**WEST SUSSEX COUNTY COUNCIL
PLANNING SERVICES CONSULTATION**

DATE: 16th October 2017

SUBJECT: LU/140/17/PL - Change of use from light industrial (B1 Business) to van sales (Sui Generis).

LOCATION: Unit 9 Minster Court Business Park, Courtwick Lane, Littlehampton, BN17 7RW.

PARKING PLAN .

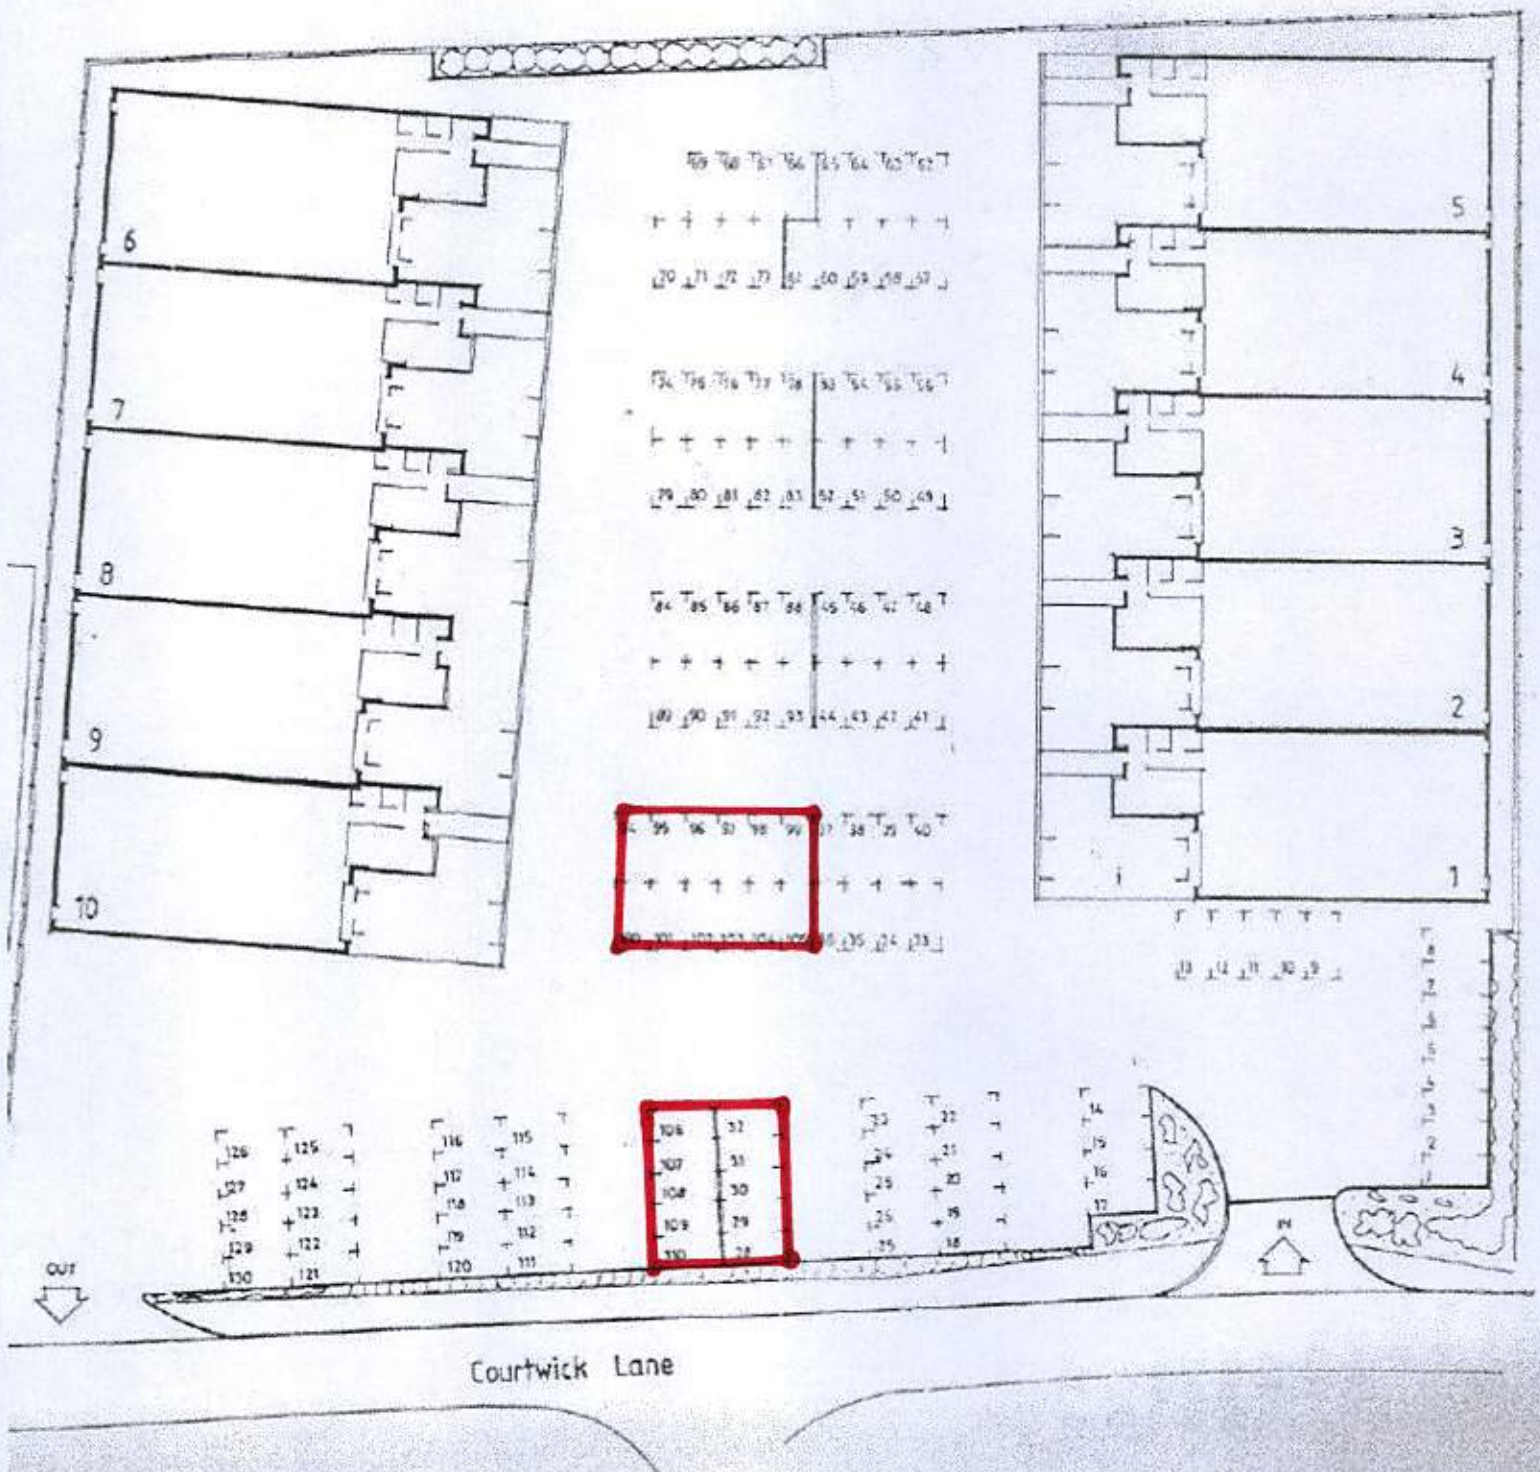
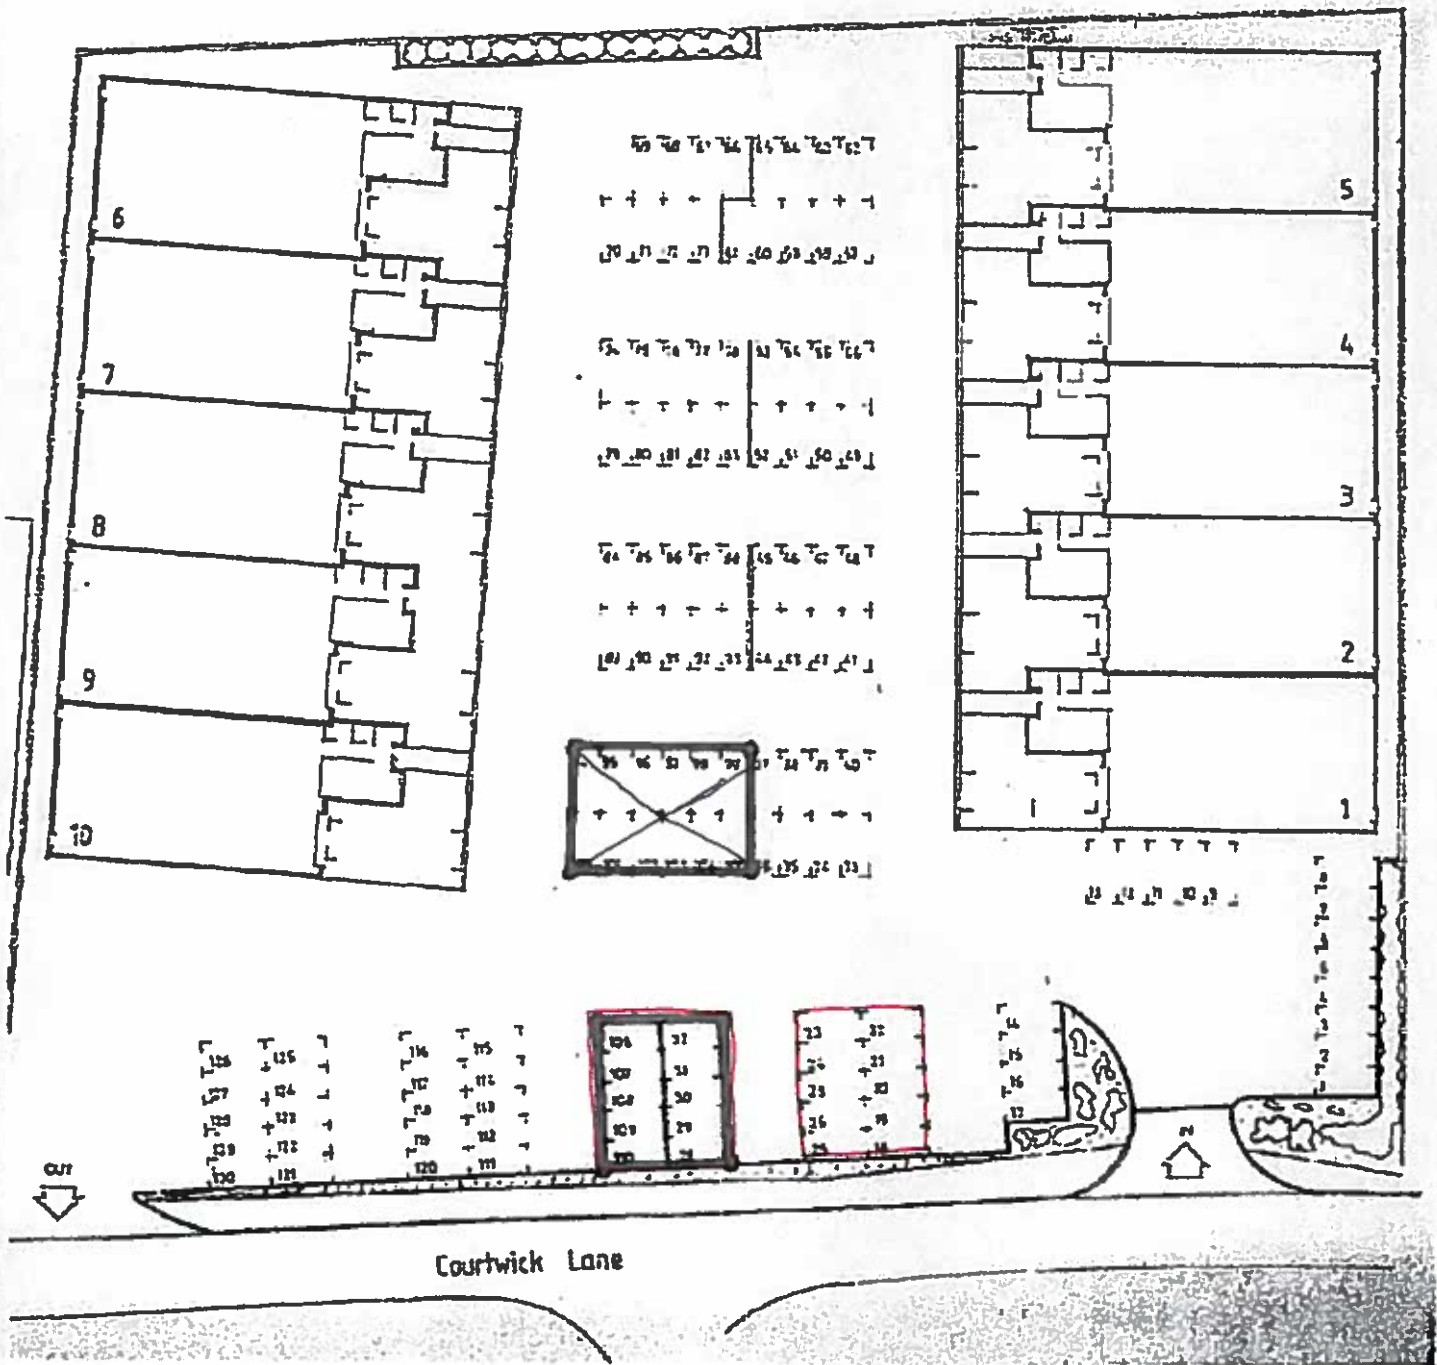
In its response dated 25th September 2017, the CHA requested sight of a clearer plan showing parking provision that would be available to the applicant for the life of any COU – including that within the building and on its curtilage (including numbers of parking spaces). In addition, written confirmation from the landlord stating that the parking spaces applied for will be made available for specific use by the applicant all the time the site is used for van sales should be provided and further explanation about the 'licence' arrangements for some of the parking should be provided.

What has been submitted is a newly marked parking plan and a copy of the lease for the applicant. This now shows 20 spaces being available to the north of the site (parking spaces 18-25 and 28-32 and 106-110). In addition to this (although not highlighted on the new plan) would be parking on the site frontage (approximately 9 spaces) and anything else within the building. This brings the amount of 'known' parking to 29 (or 27 if the parking edged in red is used as it currently is). As documented earlier by the CHA, parking guidance recommends 17 spaces + visitor and staff parking. Subject to all these spaces being made available for the life of any planning permission on the site, the number provided would appear to adequately accommodate the requirements of the business within the confines of the business park. It is recommended that a condition be attached to any planning permission granted referencing the approved drawing.

Parking Provision (details approved) - No part of the development shall be first occupied until the parking has been constructed in accordance with the approved site plan. These spaces shall thereafter be retained at all times for their designated purpose.
